Rezoning Transportation Analysis

Petition Number: 2023-029

From: Jake Carpenter, PE

Date	Description
06-28-23	First Review (TM)

**SCHEMATIC
SITE PLAN**

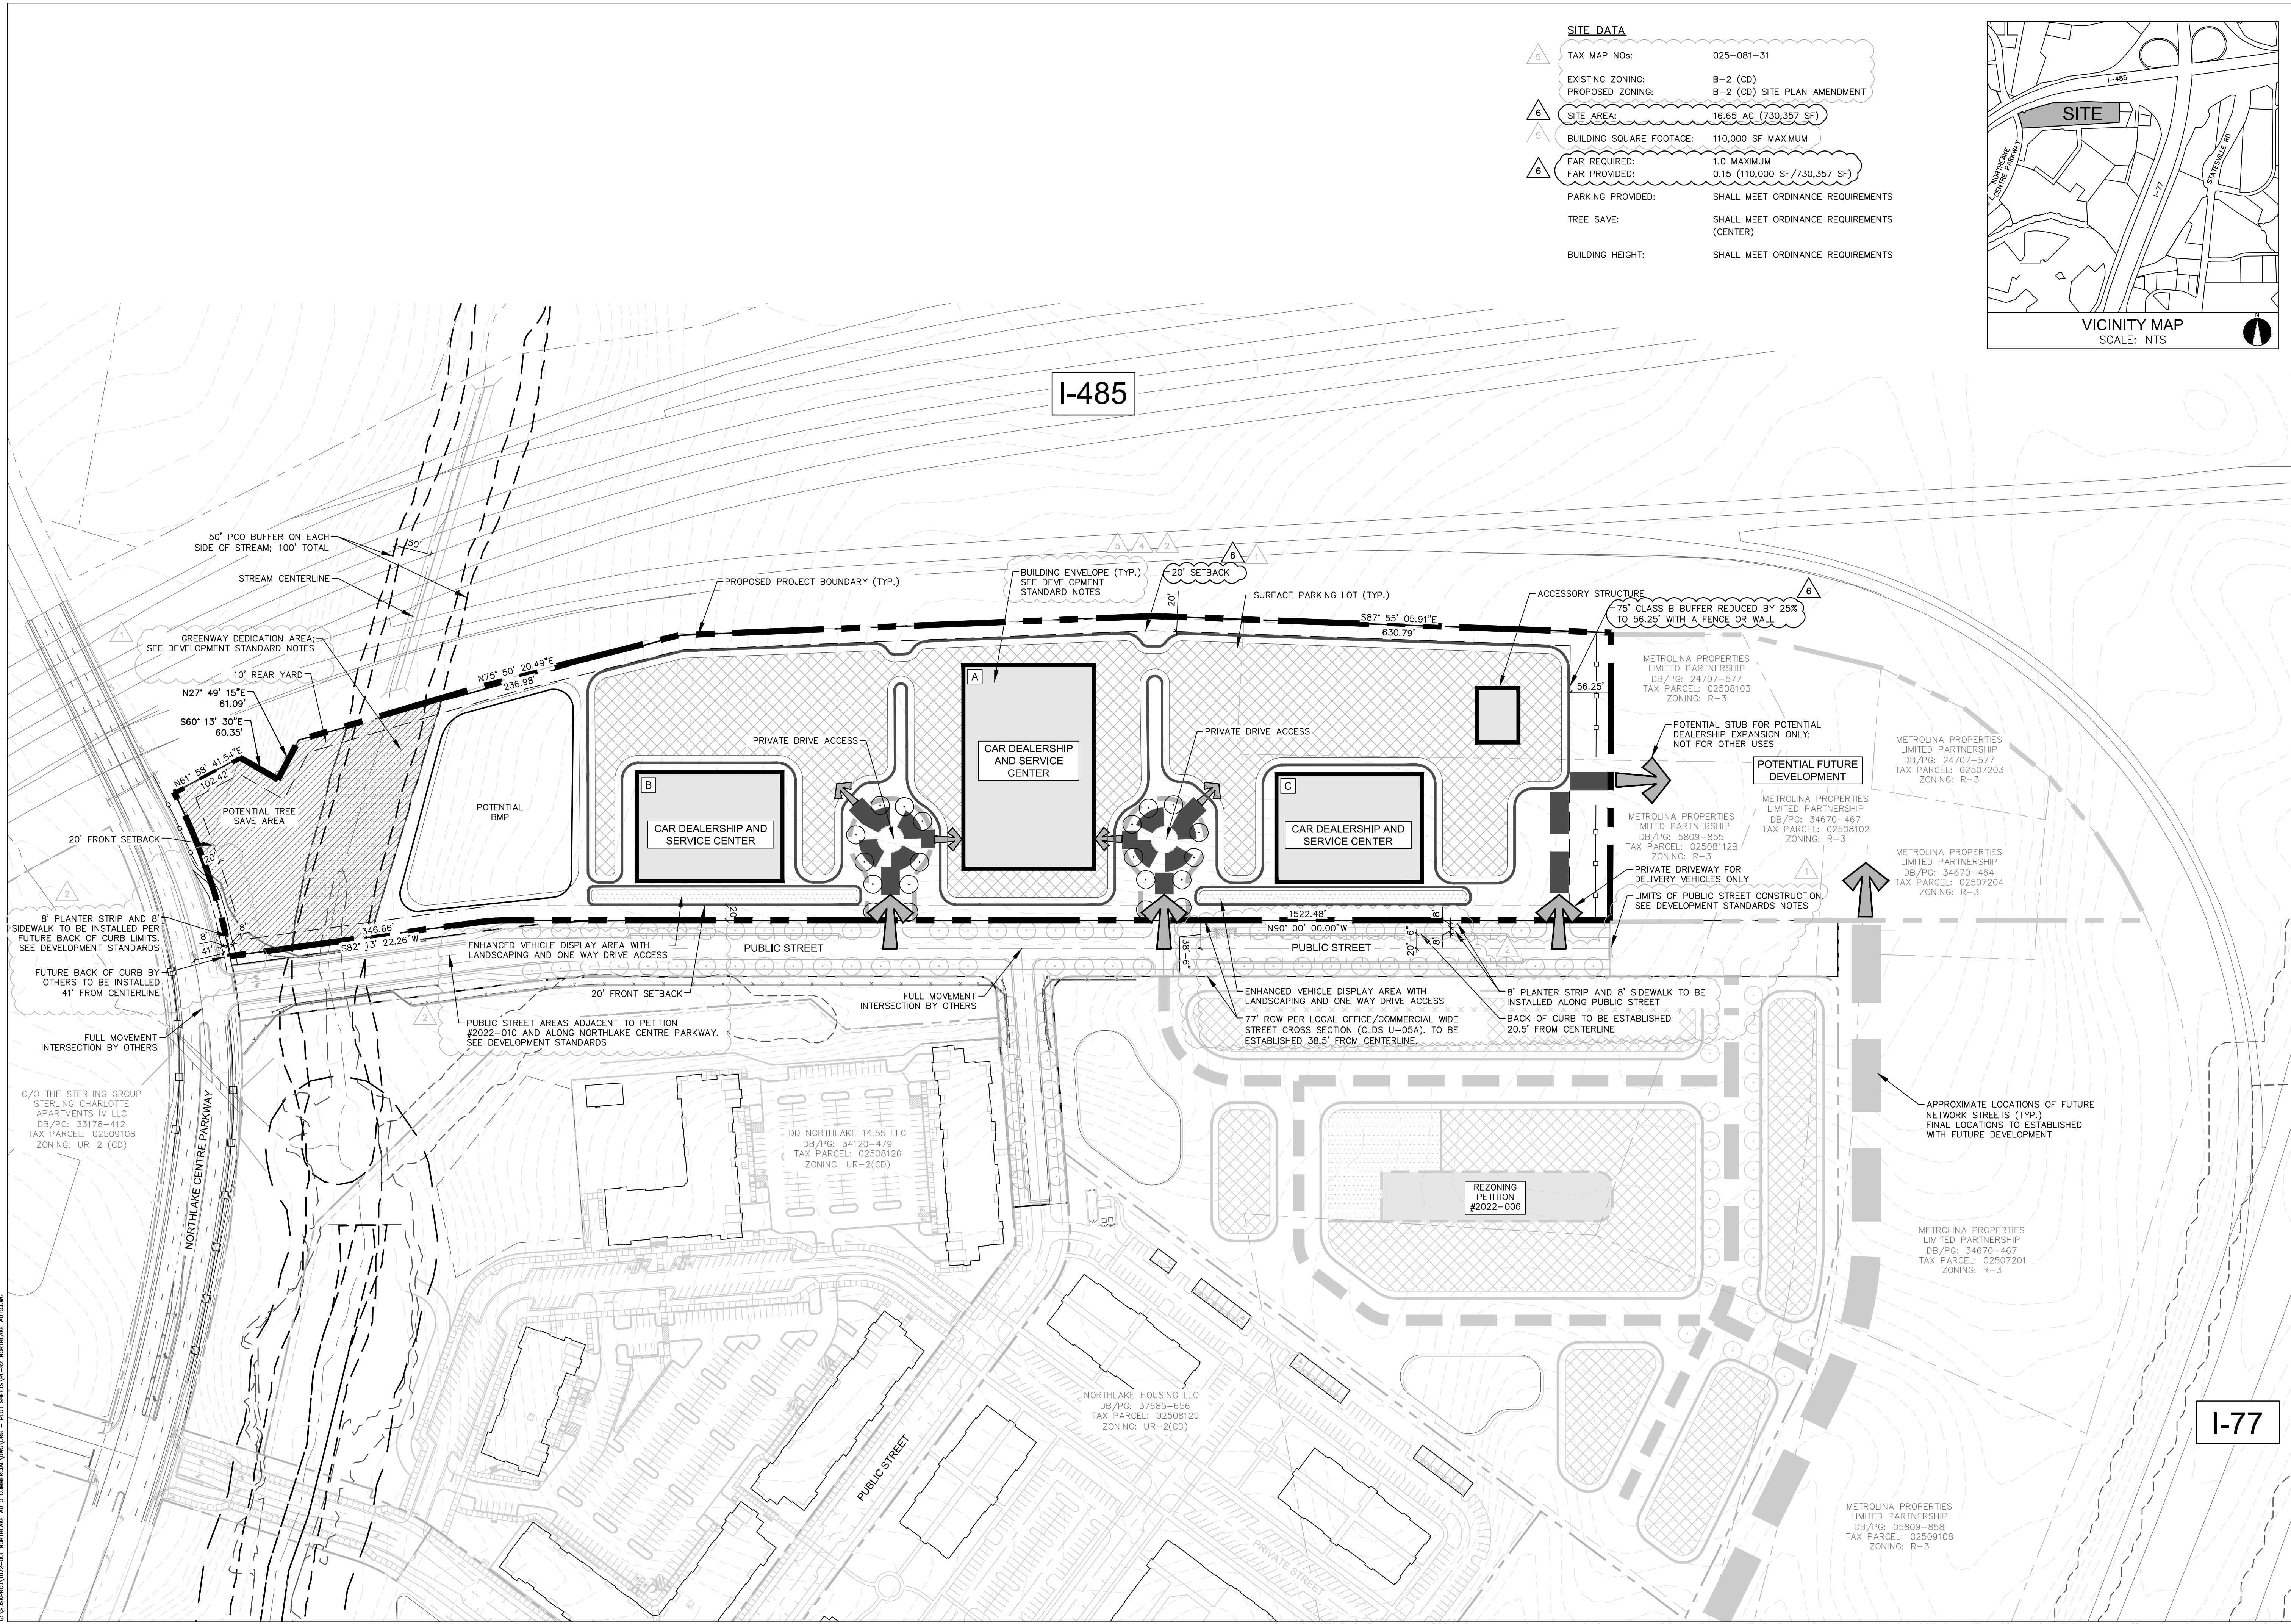
2. **Traffic Study:**
An updated Technical Traffic Memorandum is needed due to the increase in trips associated with the proposed rezoning. Provide an updated TTM for review.
3. Revise site plan and conditional note(s) to commit to adding a conditional note stating the annexation plans of the public roadway regarding maintenance of the public roadway.

**SCHEMATIC**  
**SITE PLAN**

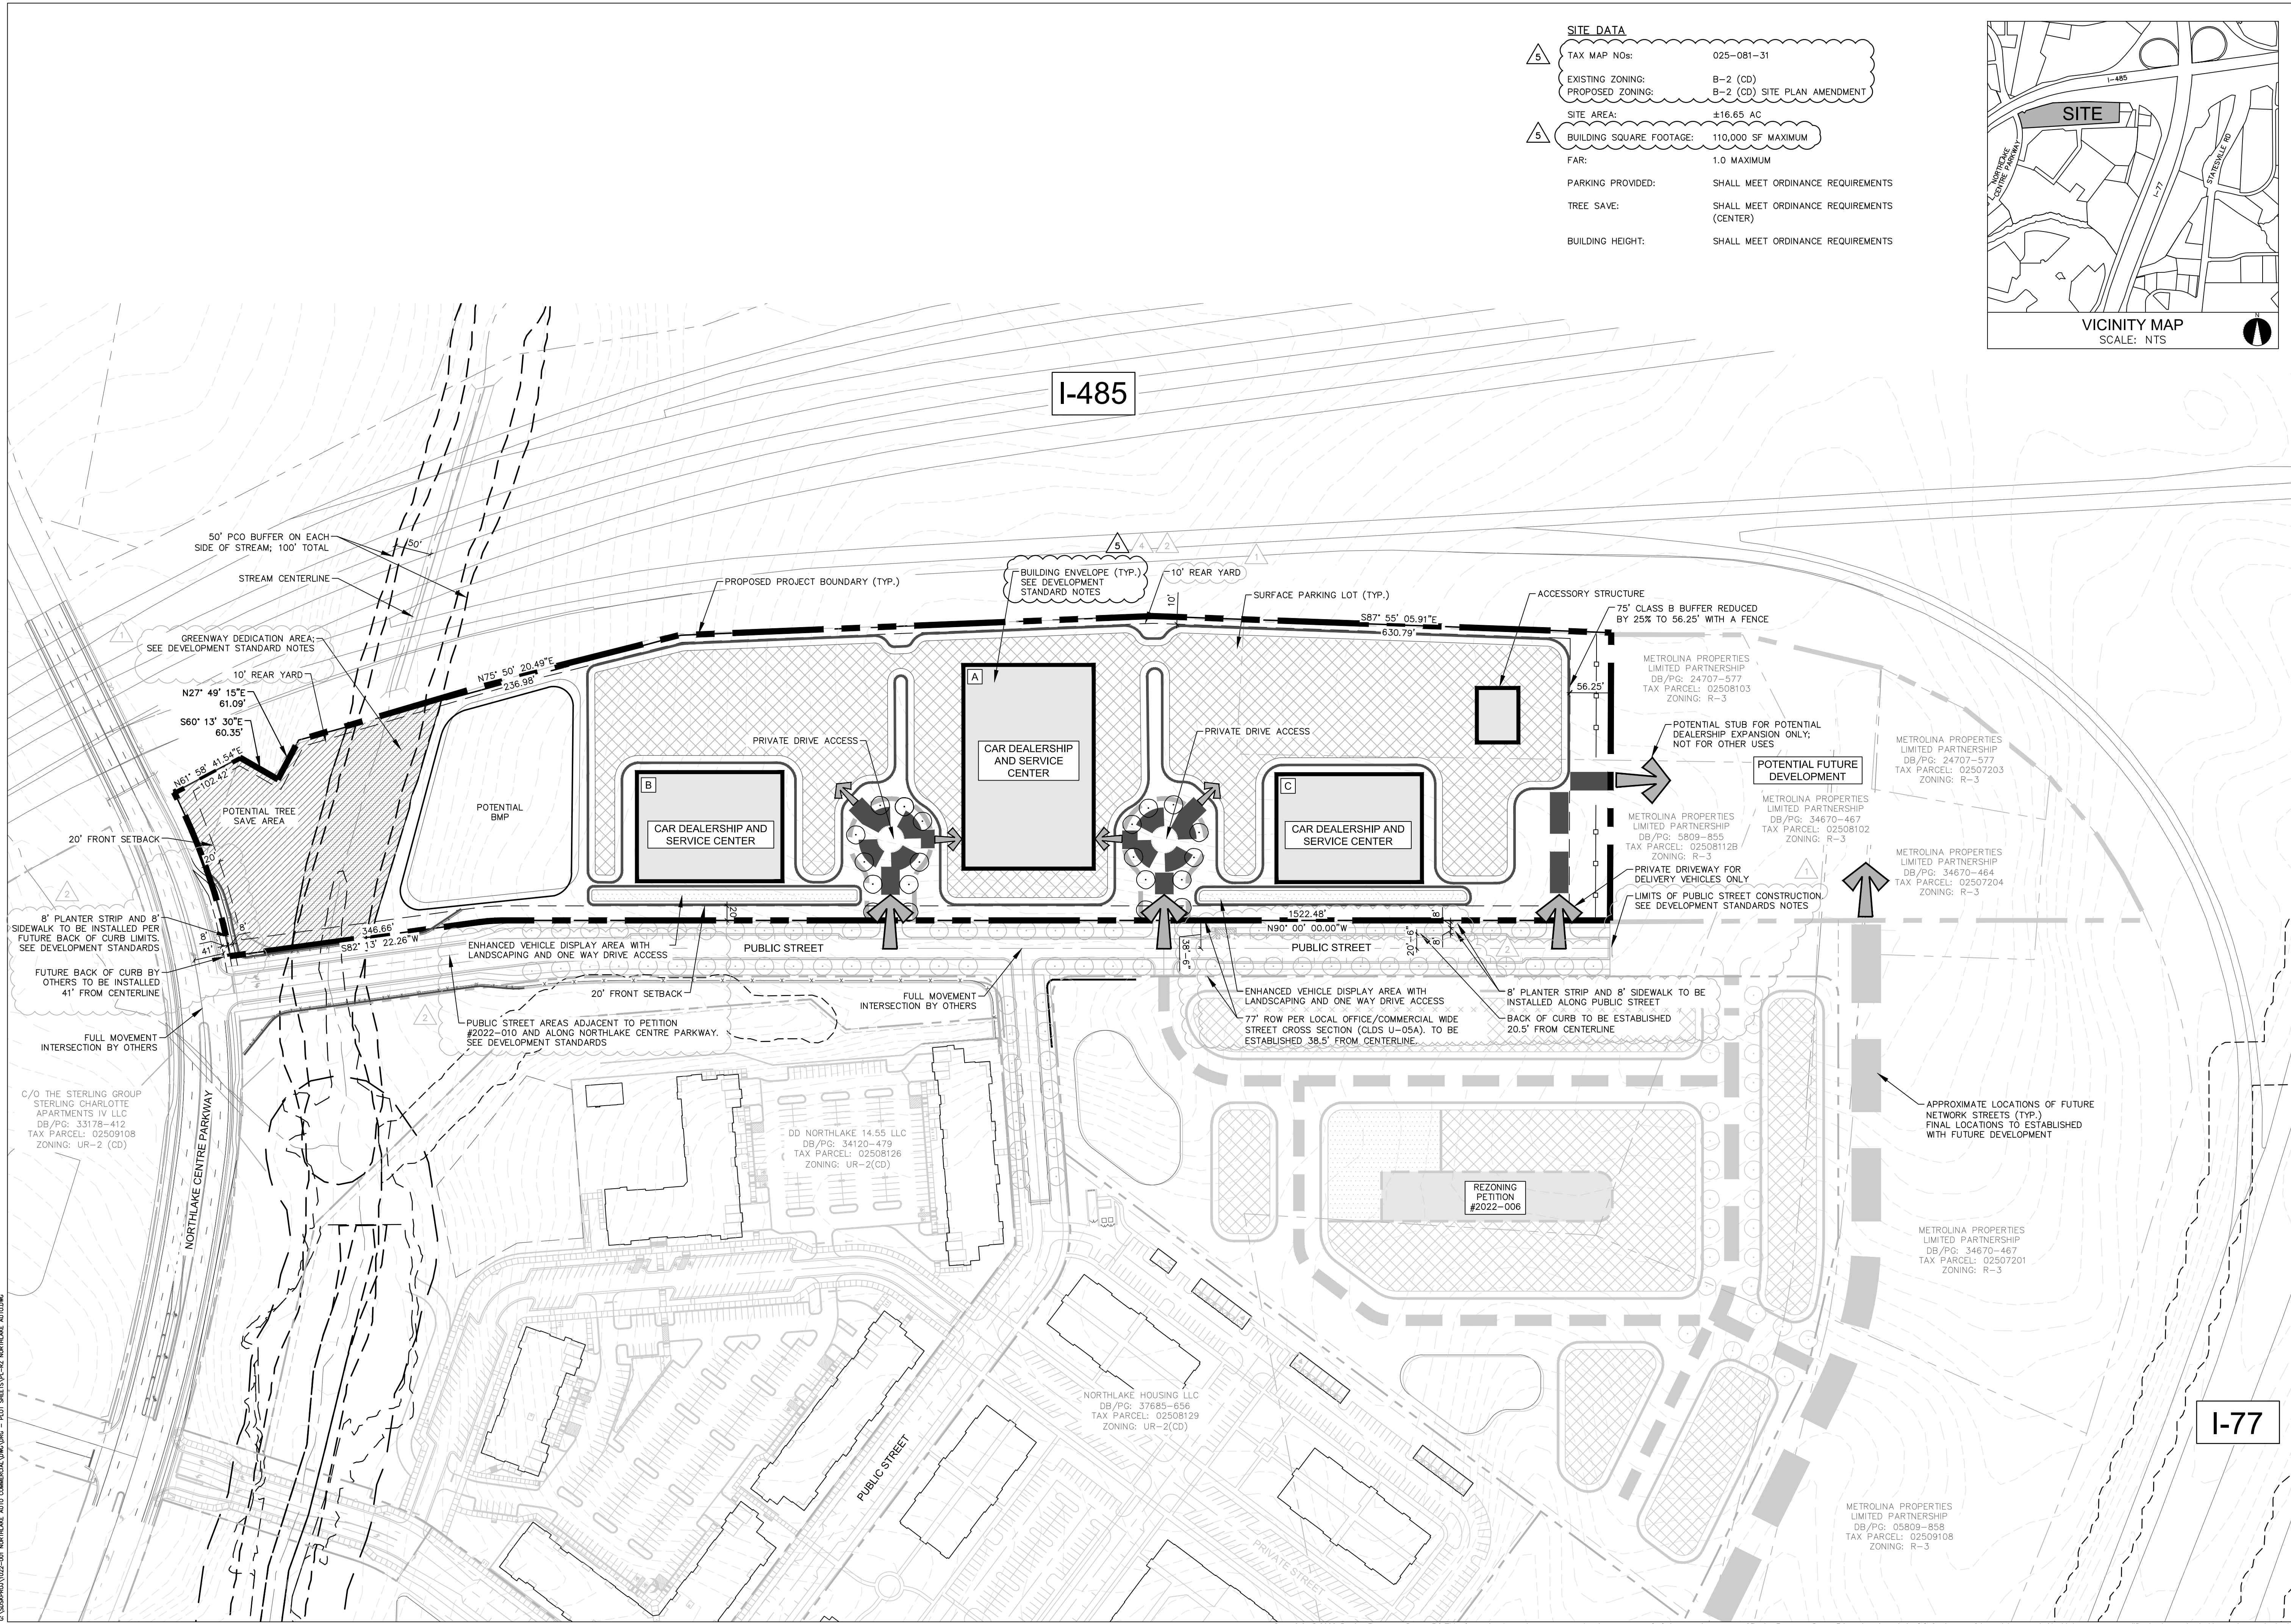
1. ~~**Curblines:** The proposed zoning district has a setback measured from back of the existing or proposed future curblines.~~
 - a. ~~**Northlake Centre Parkway:** Location of the future back of curb and gutter is 41 feet from the centerline of the roadway. Label the future back of curb location on the site plan for planning purposes. The existing curb line will not be required to be relocated for this petition.~~
 - b. ~~**Proposed Public Streets:** Location of the back of curb and gutter will be established at 20.5 feet from the proposed centerline of the proposed public streets per CLDSM U-05A for a commercial wide street typical section.~~

Label and dimension the curb and gutter from the centerline for each road on the site plan.
